Application No: AW/3/21/HH  
Site Address: 4 Shorecroft Aldwick PO21 4AS  
Description of works: Single storey rear extension and loft conversion with enlarged rear dormer window and two modest front facing dormer windows. Alterations to fenestration, Canopy to side elevation, Planter and replacement handrail to roof terrace.

Thank you for your internet representation made on 26th January 2021 which has been recorded as an objection with the comments as follows:

Drawing No. Date:
C.1062H - 04 22-12-20

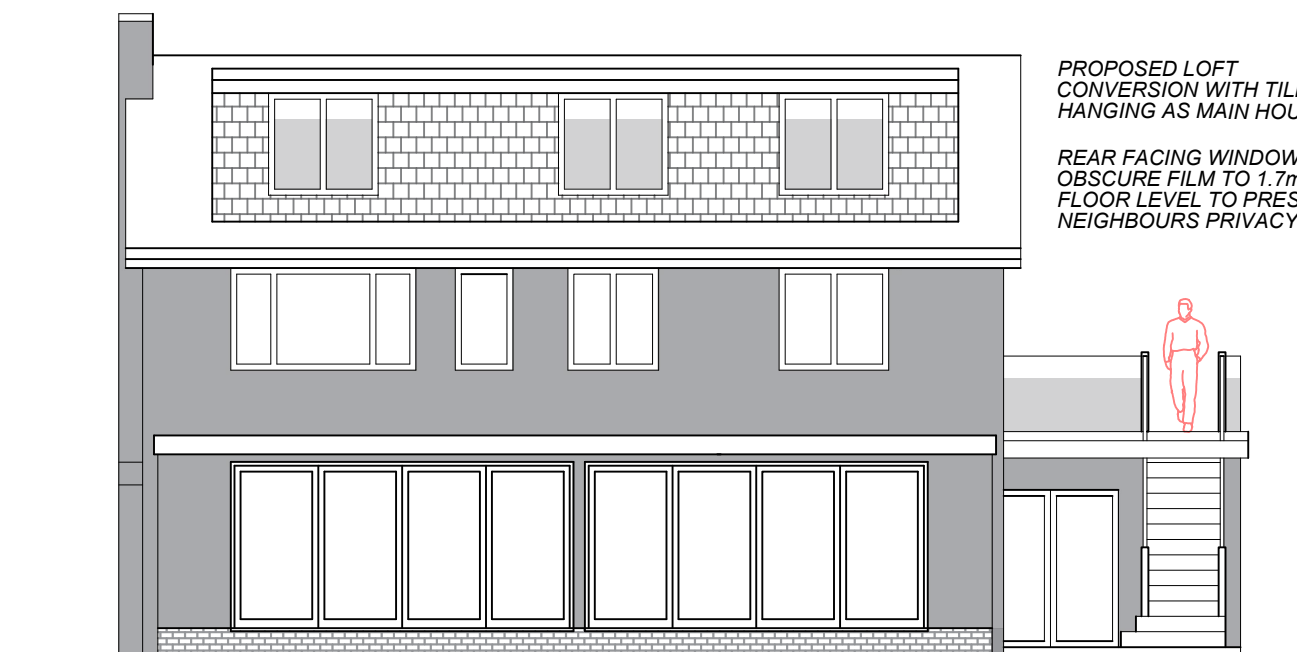
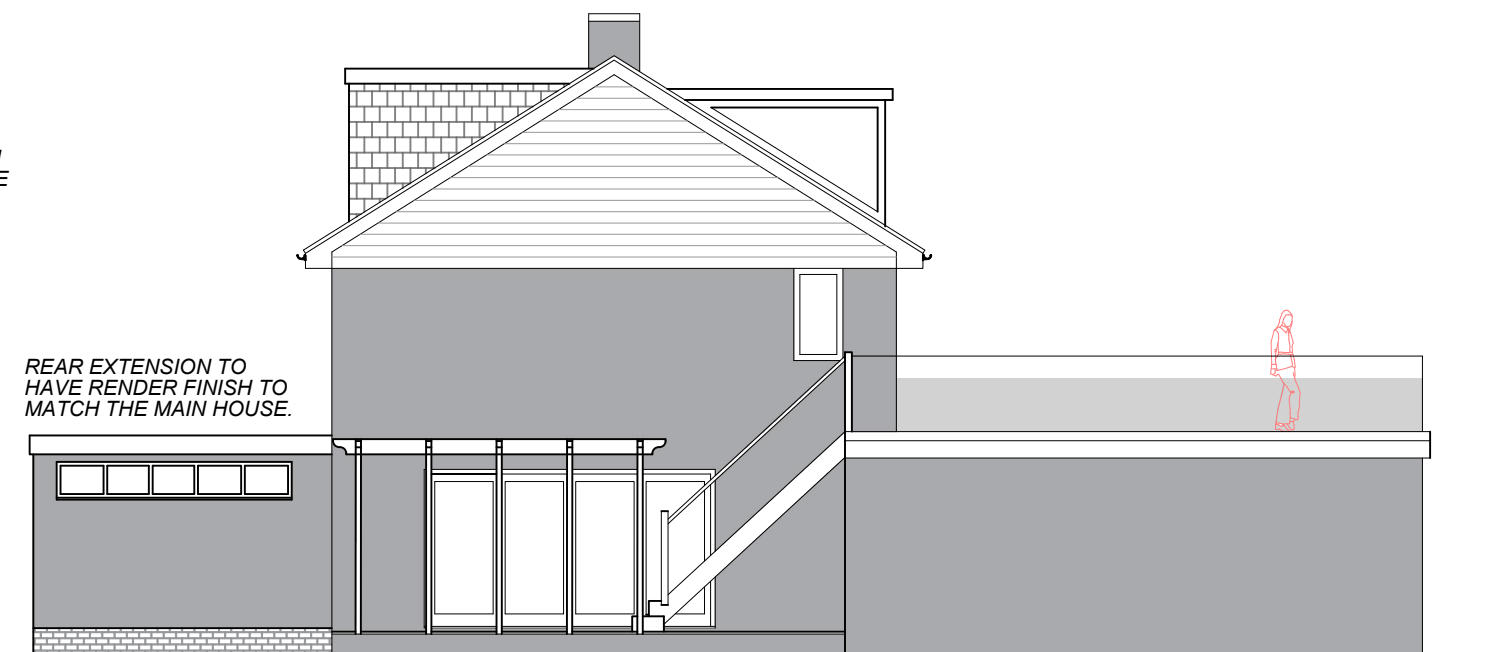
1. The large box dormer would overlook my bungalow, this intrusion of privacy would look straight into both living rooms and my conservatory, removing my privacy and amenity.

2. My garden would also be completely overlooked removing my privacy and enjoyment of my outside space.
3. My garden is approximately 30ft from their boundary, my conservatory less than 12 ft, the applicants garden is of a similar length, this box dormer would dominate over our property.

4. The proposed obscure film to the lower half of the windows is not an adequate permanent solution to protect me from this overbearing roof extension.

5. This addition is totally out of character, closely backing onto three smaller bungalows and would be overwhelming in appearance. I suggest this box is replaced with roof lights following the roof line, this would give the light required but without ruining the amenity of their rear neighbours.

6. The height of the dormer precludes any possible screening for the three bungalows at their rear.
7. This roof box dormer would make this the only property with three levels of accommodation on this private estate and is out of keeping with this estate area.
